Application Number SSD-101842729

Proposal Detailed State Significant Development Application for a residential development with in-fill affordable housing

Location 2-6 Conway Avenue, 15-15A Fernleigh Avenue & 38-40 Carlisle Street, Rose Bay

Figure 2: Cross section showing height exceedances (Source: MHNDU Architects)

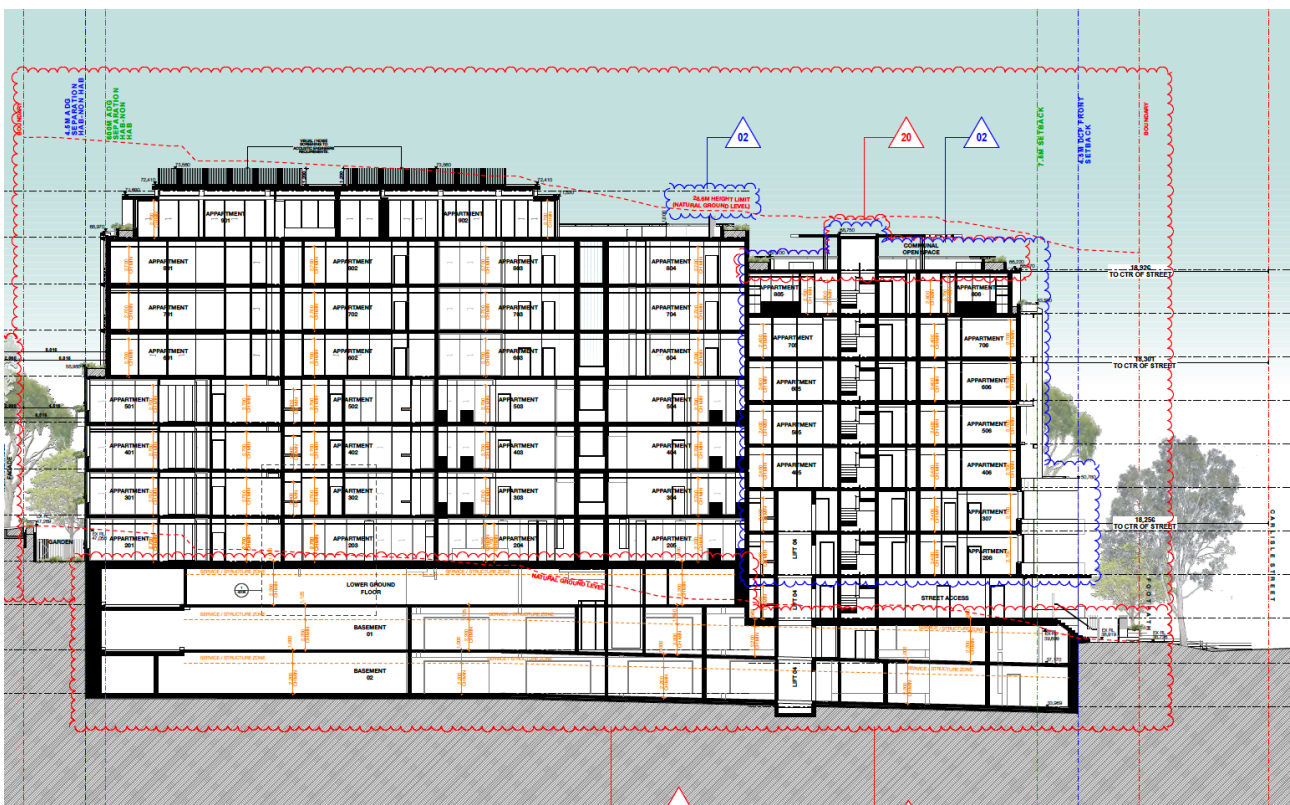
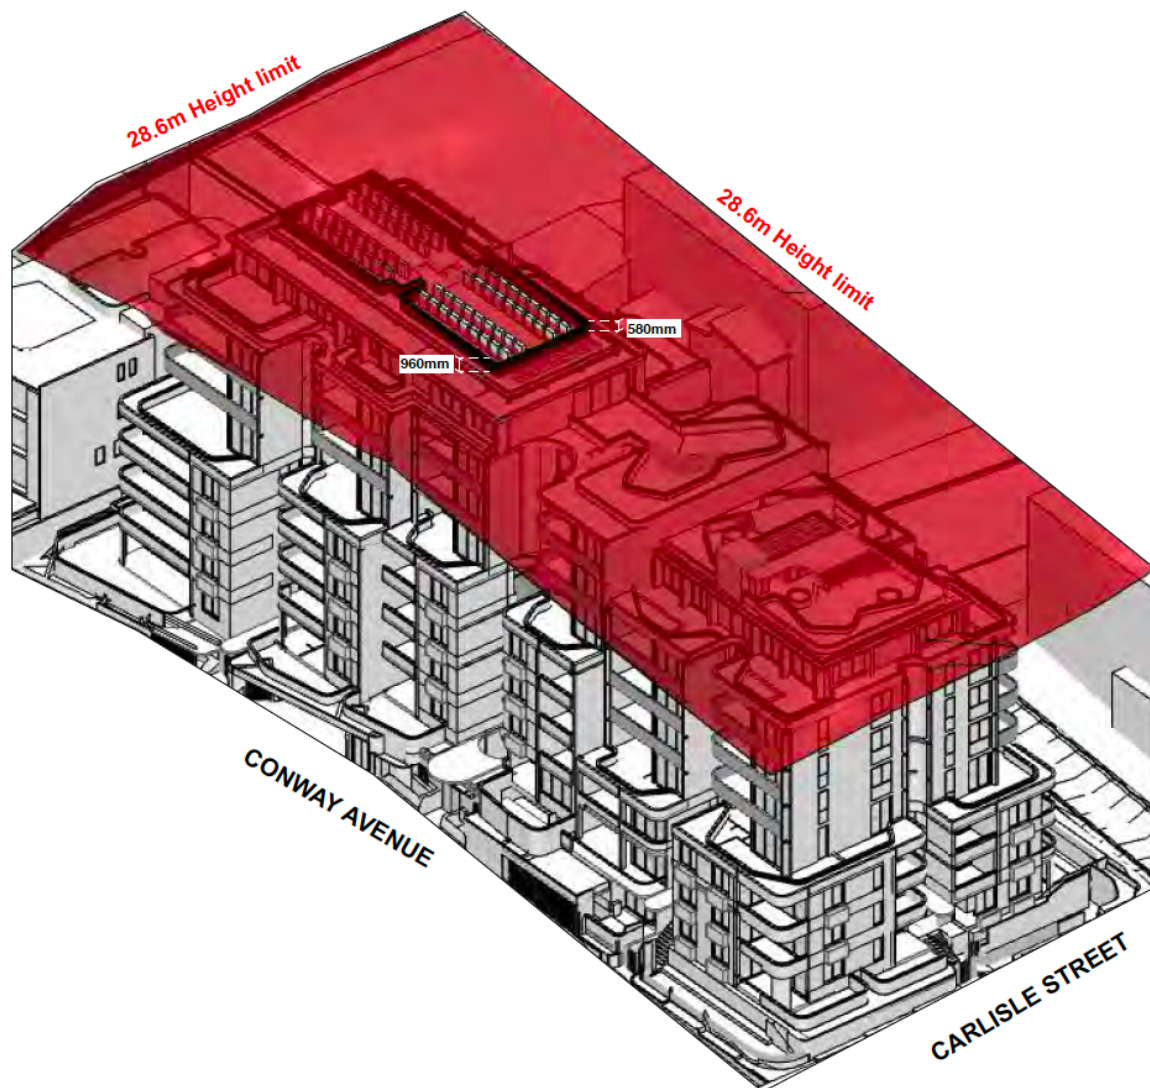
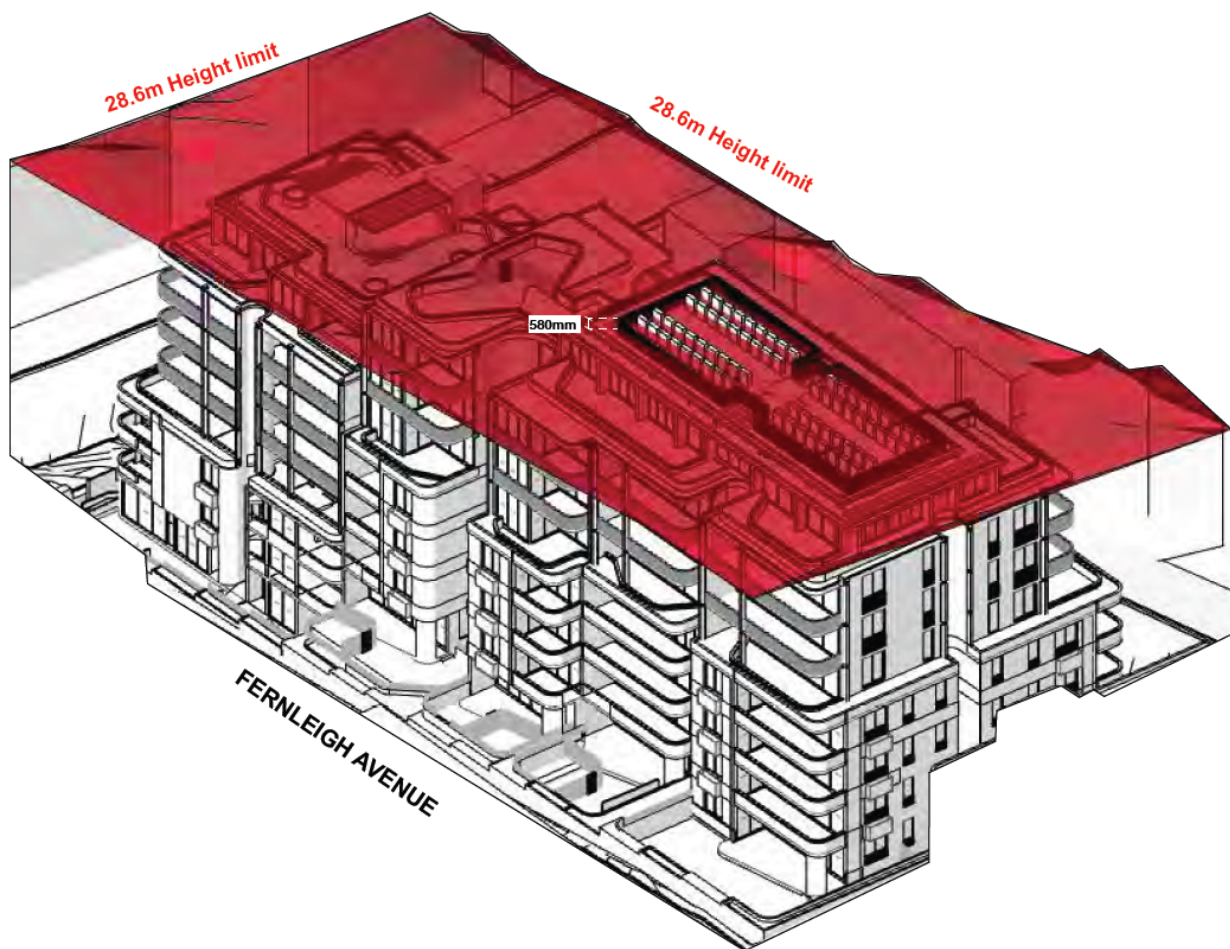
The existing ground level and 28.6m height plane depicted on the architectural drawings fails to accurately represent the existing ground levels shown on the site survey. For example, the front setback of No. 2 Conway has an RL of 41.65 and this RL continues into the site. The proposed building in this location has an RL of 72.26, which means a non-compliant height of 30.7m.

The existing ground level as depicted, also appears to not depict the car parking below the existing dwellings to Fernleigh Avenue, and the numerous swimming pools within the site.

The adopted method for calculating the height is contrary to the definitions for 'building height' and 'ground level (existing)' contained within the WLEP 2014.

Extrapolating a height plane has been accepted by the NSW LEC court in cases where the existing ground level is not known (i.e. because the entire site is covered by a building). However, it has been established (*Stamford Property Services Pty Ltd v City of Sydney [2015] NSWLEC 1189* and *Gejo Pty Ltd v Canterbury-Bankstown Council [2017] NSWLEC 1712*) that this method is not intended to overrule the LEP definitions. Given that the site has been surveyed and the existing ground levels are known, the definitions in the WLEP 2014 must be used to calculate height.
